SICEEP – ICC Hotel SSDA6 - Response to Public Submissions

21st December, 4pm

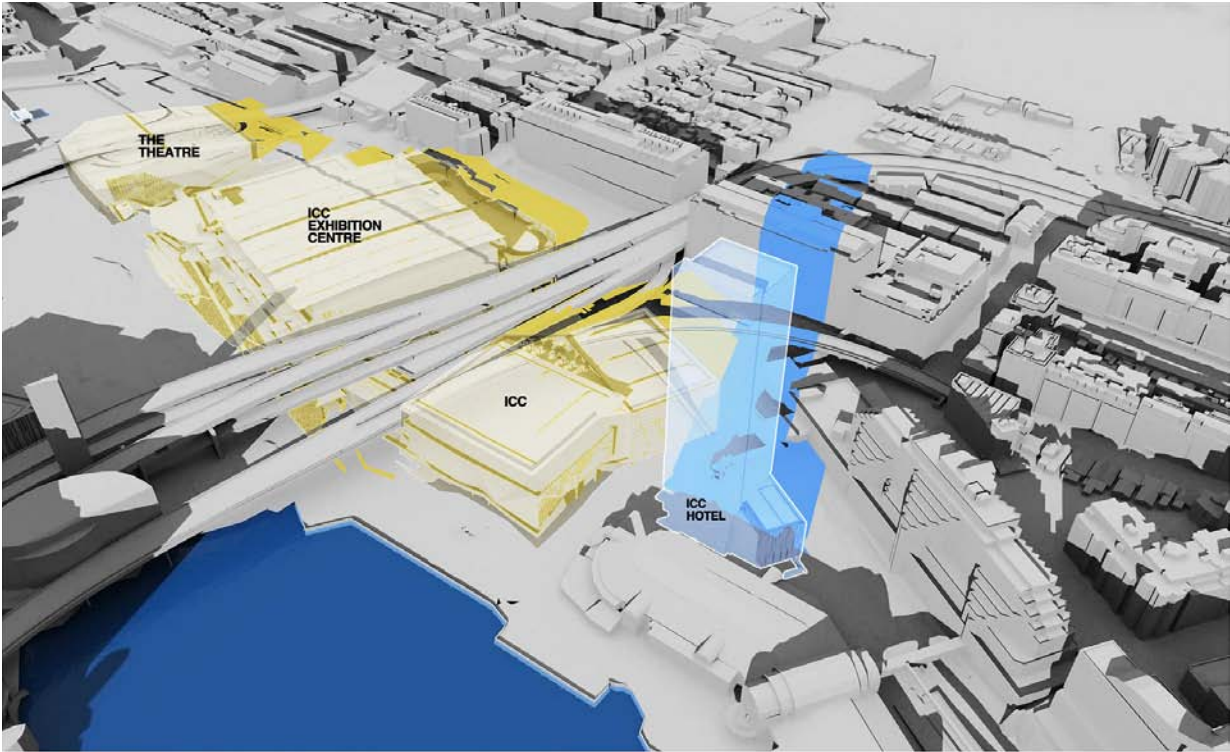
1	Shadowing cast over public walk ways on a summer afternoon is going to be extensive. And beyond the 4pm sample.	
10	Overshadowing in the morning of Pyrmont Ultimo area will affect rooftop gardens, balcony gardens, parks and streets, making it darker and less pleasant to enjoy these spaces. This will result in increased heating costs and contradicting making Sydney's buildings more environmentally friendly.	
1	Reducing the hours of solar access in mid-winter available to some residents of Oaks Goldsbrough apartments to 3 – 4 hours is unreasonable.	<p>As above, the redesign of the Hotel from the master plan stage, consisting of a single tower, has meant a significant reduction in overshadowing impacts on the public domain and surrounding buildings. Overall, given the slender design and orientation of the tower, additional shadowing of surrounding buildings and public spaces is minimal. This is evident within the original detailed shadow analysis diagrams (further updated and included within Appendix C of the Response to Submissions) which confirms the shadow cast from the hotel is narrow and moves quickly across the day.</p> <p>The extent of additional overshadowing caused by the hotel is importantly confined only to a portion of the east façade of the Goldsbrough apartment building during 9am and 10am during the worst case scenario (i.e. mid-winter). So for the remaining part of the day during mid-winter that façade receives sunlight (between 3 – 4 hours) there will be no additional shadow impacts. For the remainder of the year the east façade of the Goldsbrough apartment building will receive over 3 hours of sunlight/daylight. With key planning guidelines recommending that residential apartments should receive at least 2 hours of sunlight between 9am and 3pm during mid-winter, the proposal more than ensures the protection of amenity to surrounding residential apartments in terms of sunlight/daylight access.</p>
